Date: 9<sup>th</sup> December 2024  
Our Ref: 20050384  
Your Ref: EN010135  
Site address: Stonestreet Green Solar

**RE: Application Ref. EN010135 – Solar photovoltaic array plus energy storage with associated infrastructure and grid connection, with a generating capacity greater than 50MW.**

This letter is written in response to the Stone Street Green Solar Written Representations request which are due on the 9<sup>th</sup> of December 2024. Kent Wildlife Trust's Written Representations expand on the comments made during the Relevant Representations, which were submitted in September 2024. Kent Wildlife Trust's remit includes impacts to biodiversity within Kent. We have reviewed relevant documents submitted within the DCO against national and local legislation and policy. A summary of our main concerns is described in the box below, with more detailed comments in the main body of the letter.

Document Name:
Environmental
Statement Figure 9.5:
East Stour River
Proximity Plan
- Sheet 3 of 3

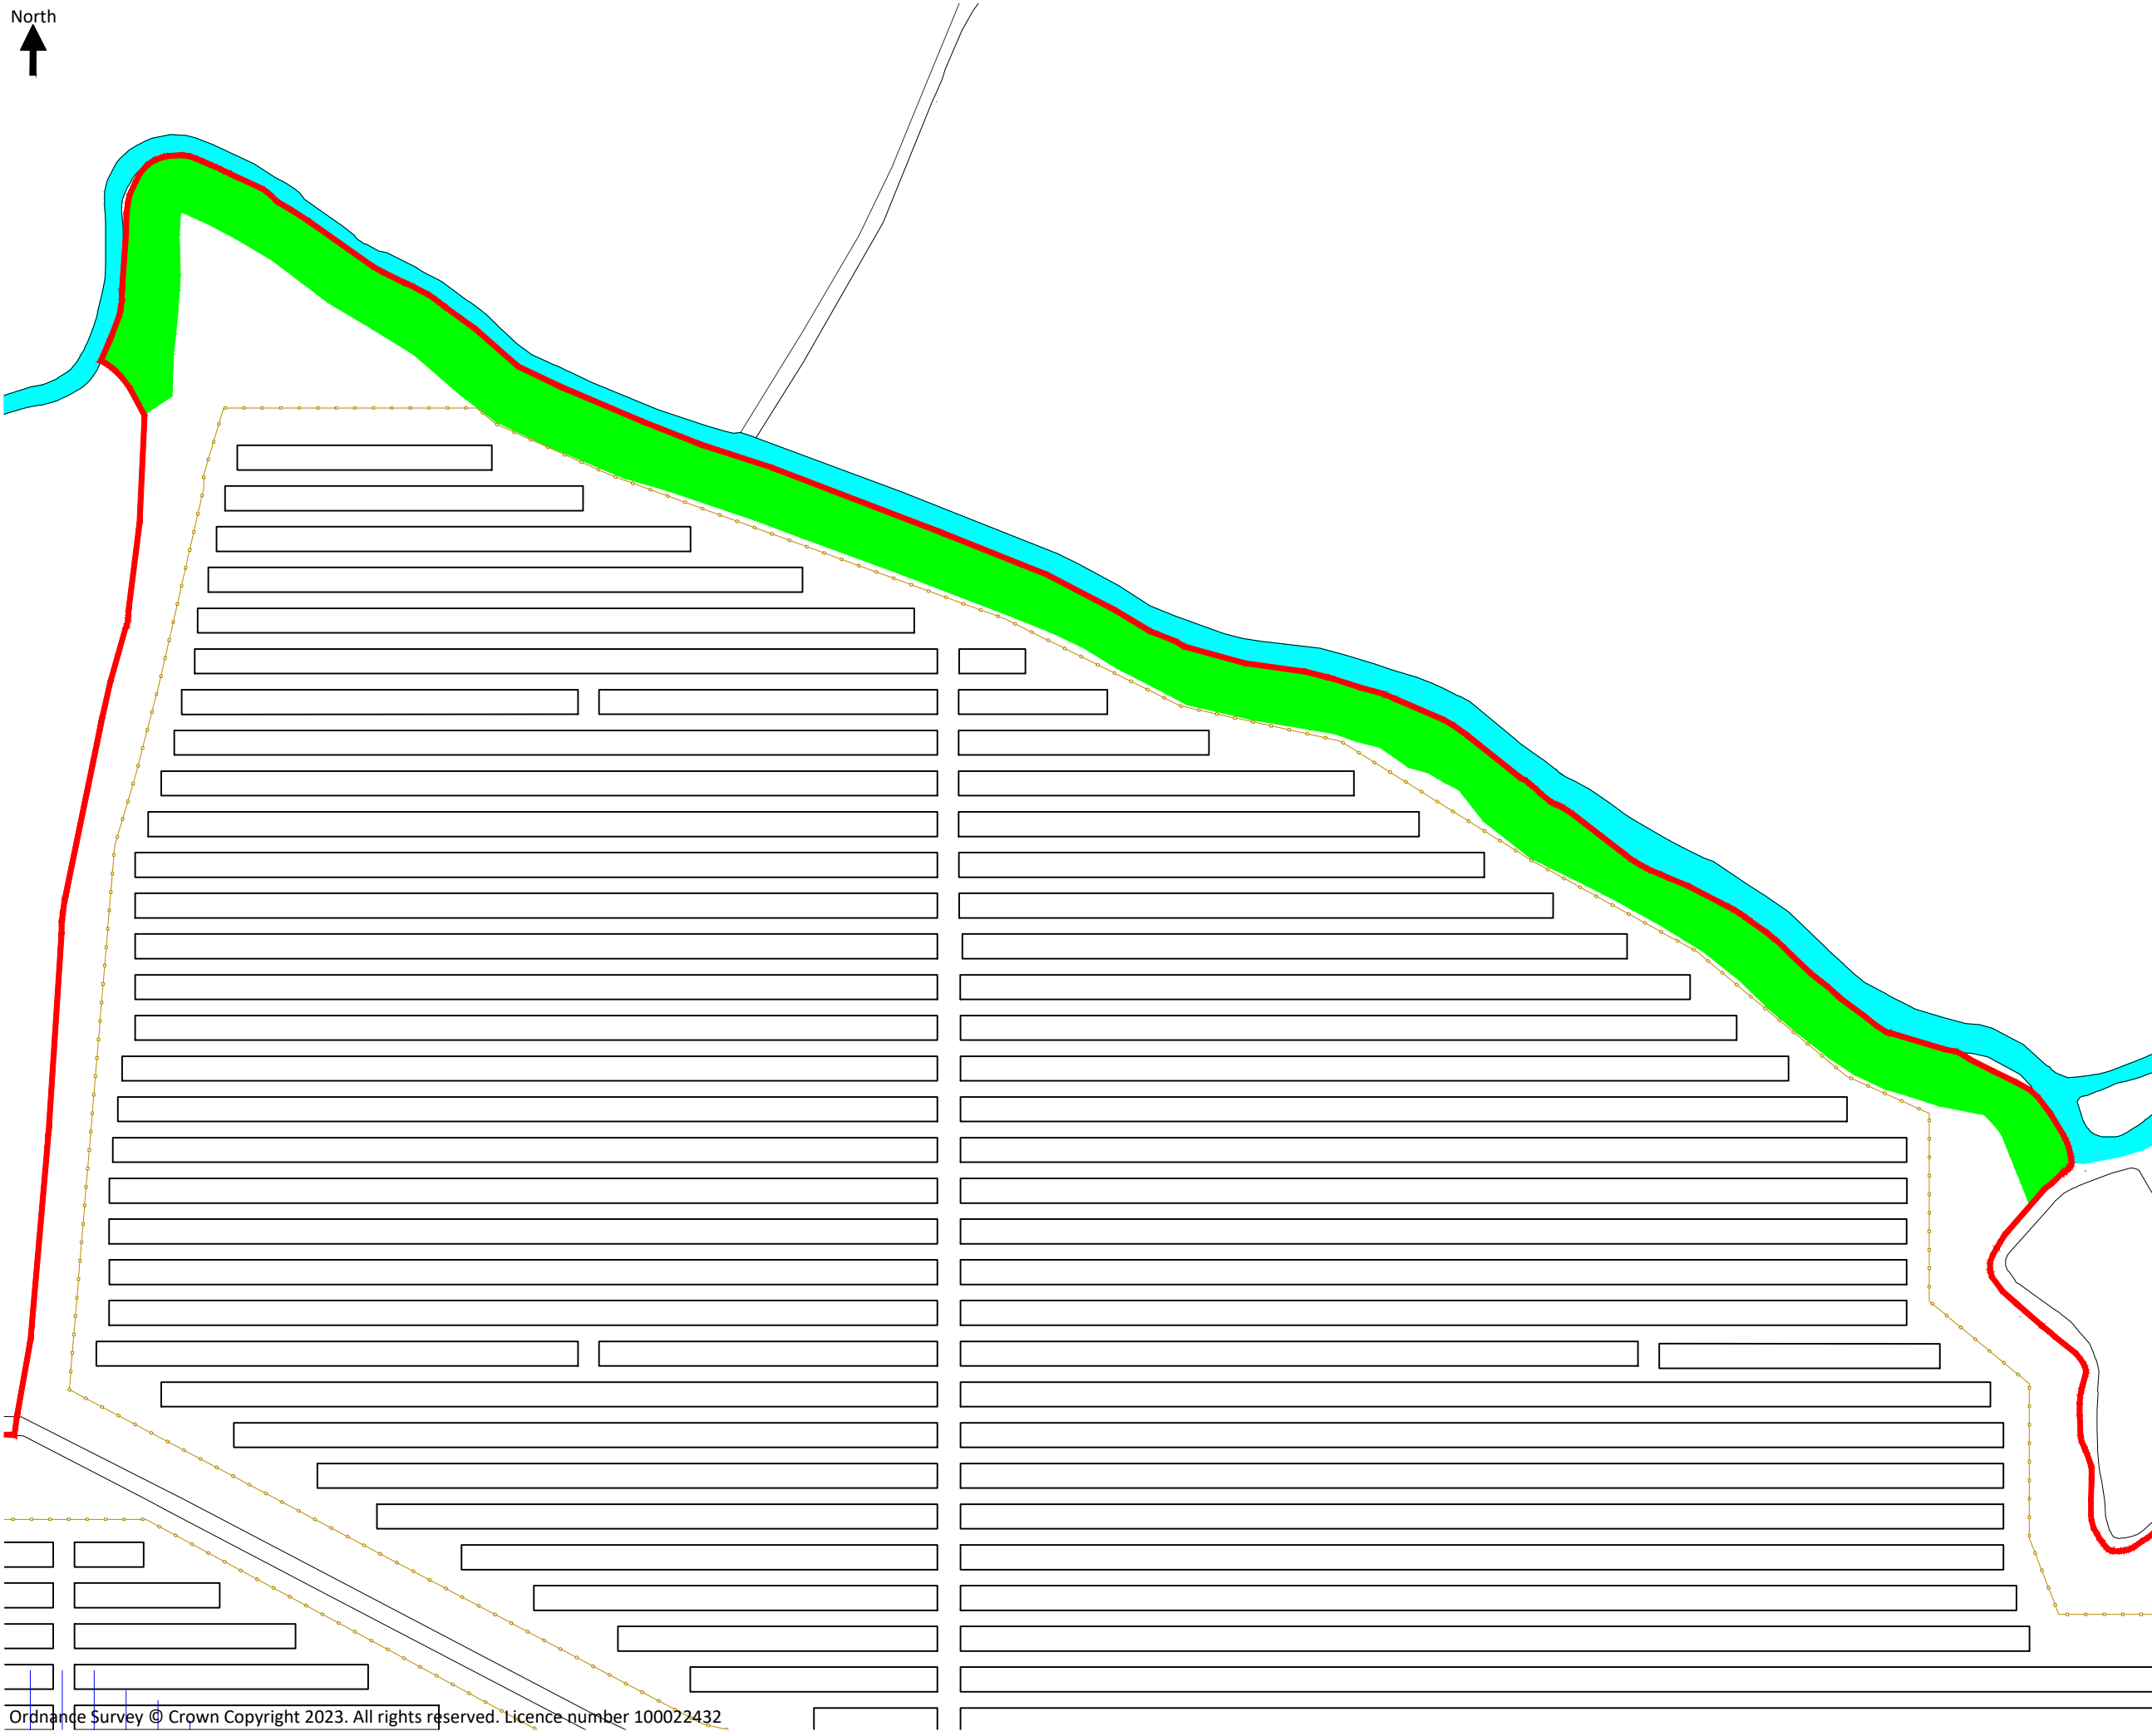
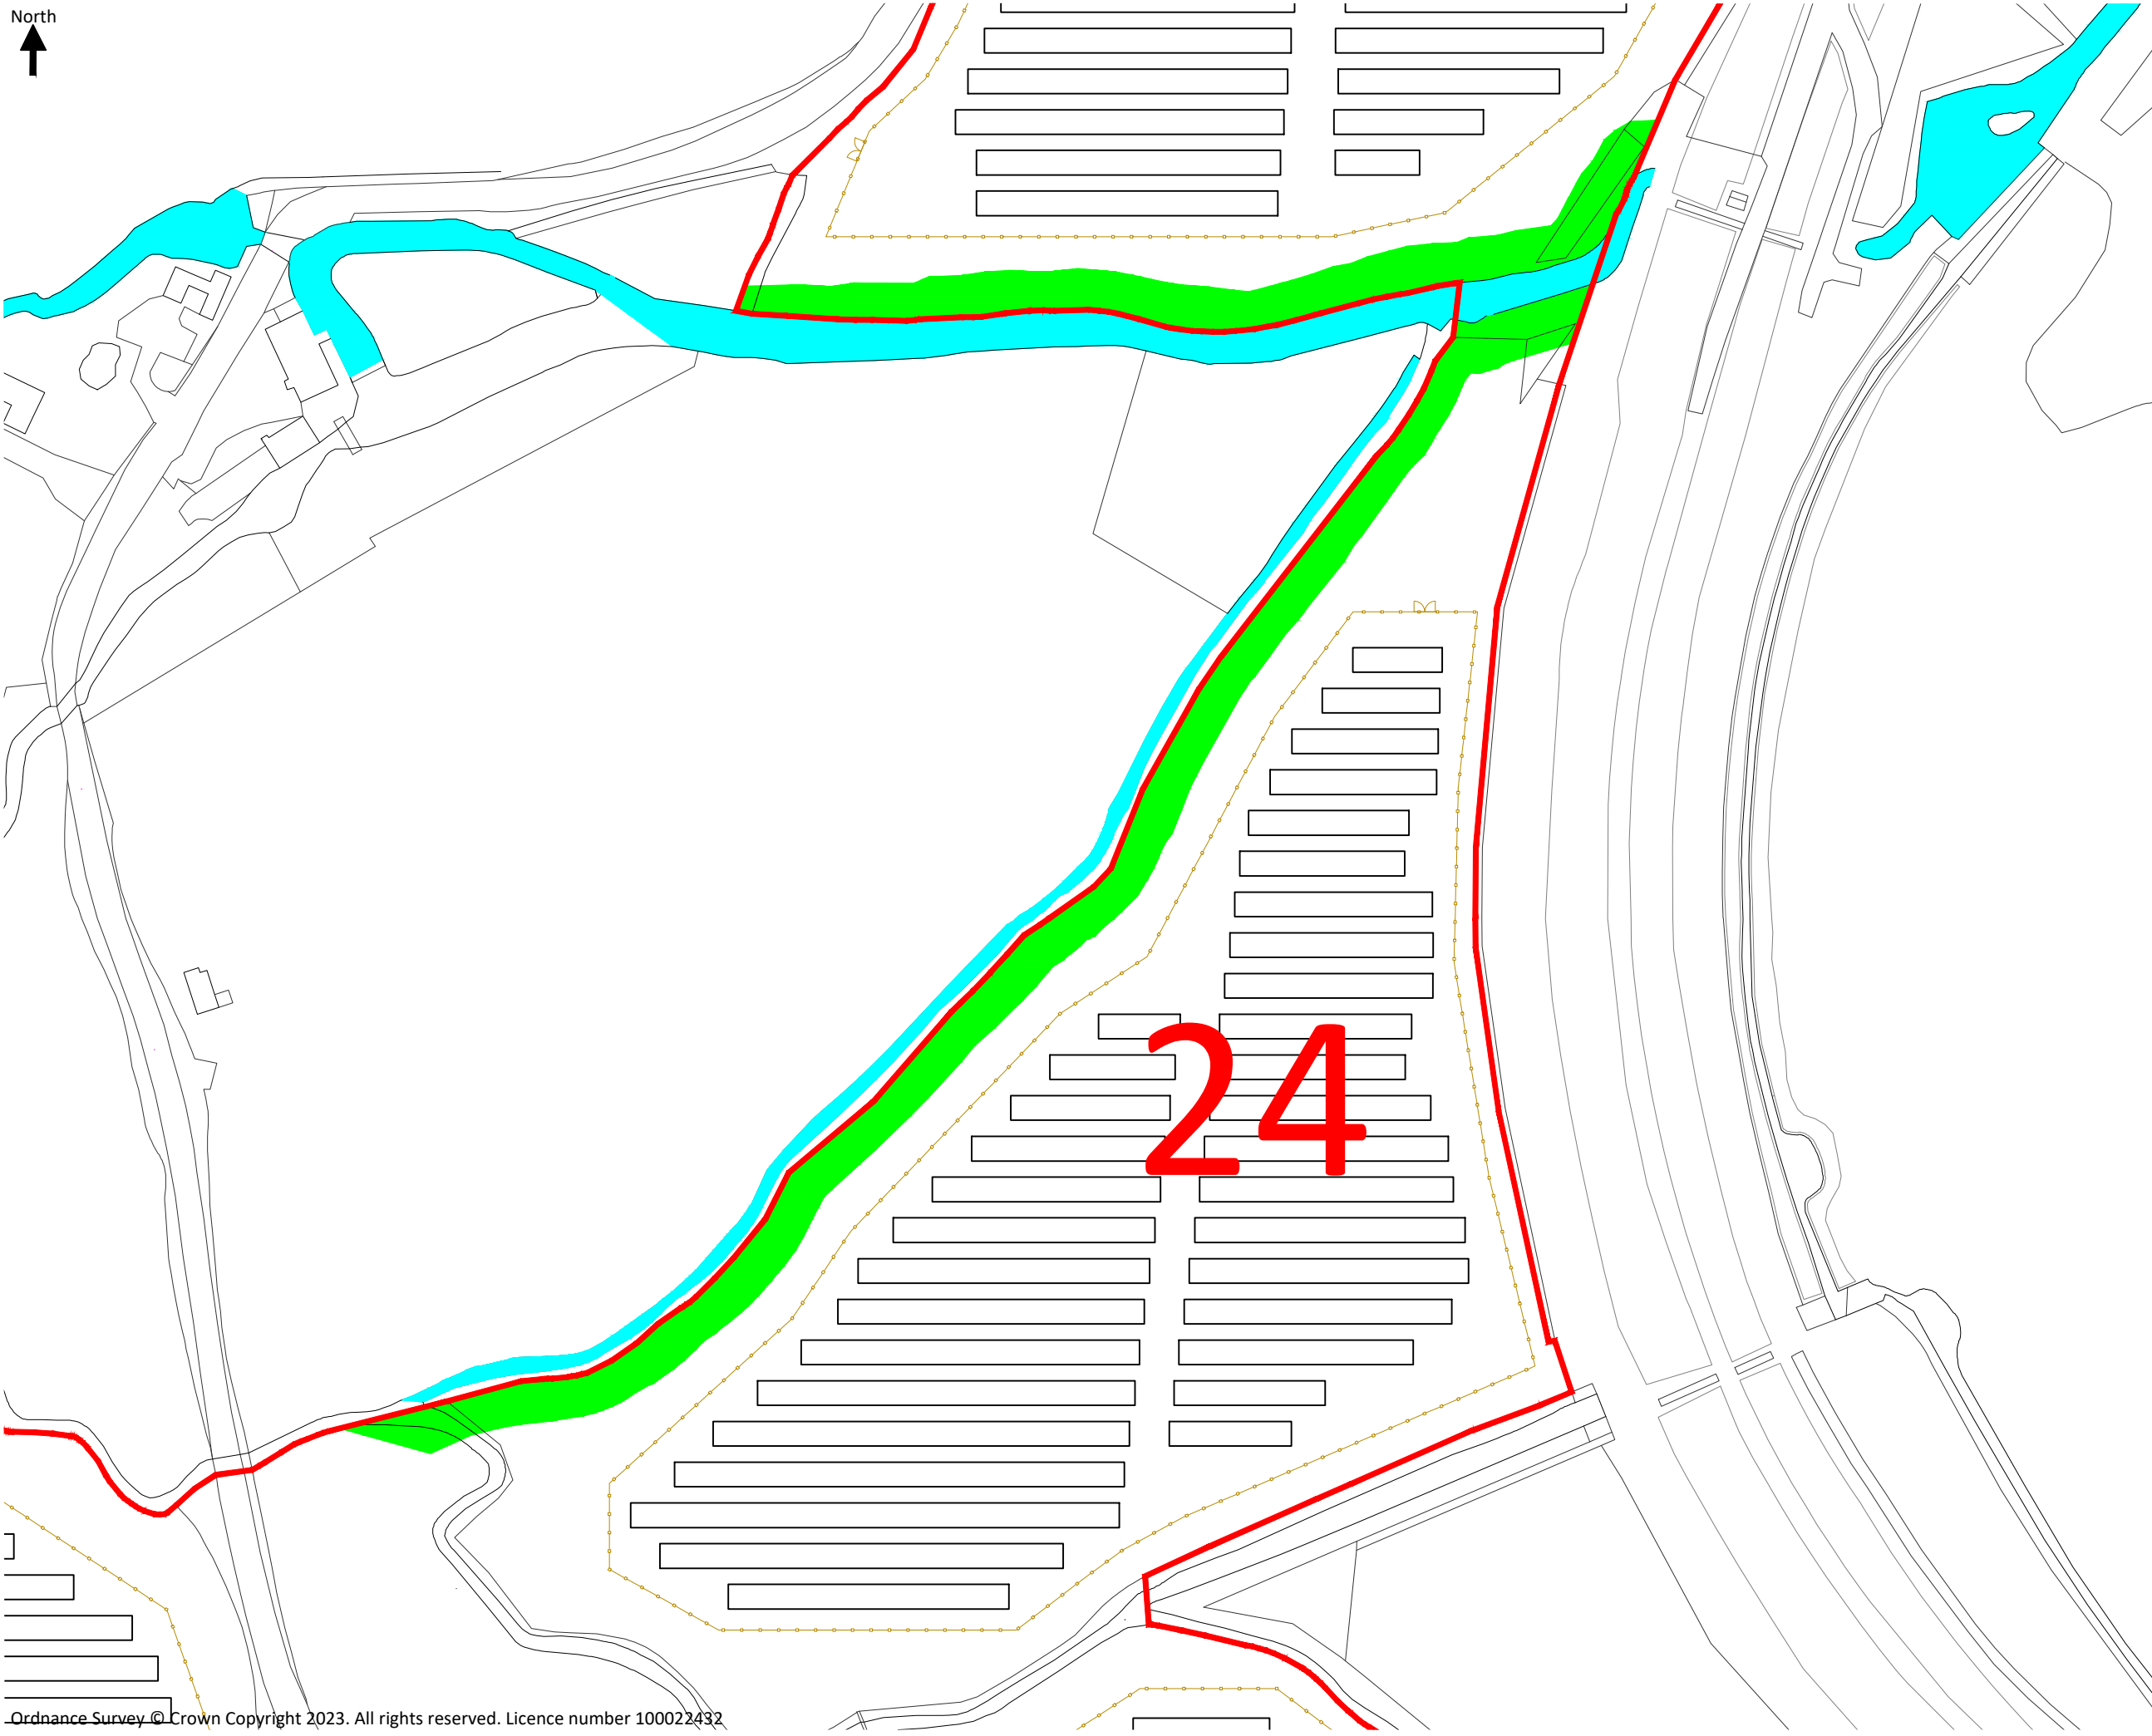
KWT wish to raise concerns about the proposed use of horizontal directional drilling (HDD) under the East Stour River. We have been told as part of the Sea Link project, which is currently going through the NSIP process, that it is not possible to carry out HDD under the Stour. Security is therefore needed that this process can be achieved given the conflicting lines from different projects. Sufficient information also needs to be provided on what alternative approaches will be considered if HDD is not possible along with full assessments of the ecological impacts of these alternative options. In addition, no measures have been put in place around what remedial action will be taken in the event that there is an unexpected issue while HDD is being undertaken.

Insufficient information has been provided to clearly establish that the proposed sites for temporary bridges over the East Stour River are suitable in terms of the condition of the riverbanks. We are therefore concerned about the risks that such an approach poses to the integrity of the riverbanks and the ongoing protection and enhancement of the river.

Limited information has been provided on the proposed foul water collection and treatment process as a means of removing potential impacts to the East Stour River from surface water flooding. We are concerned about the effectiveness of this approach and the biodiversity impacts of implementing this system prior to the commencement of development.
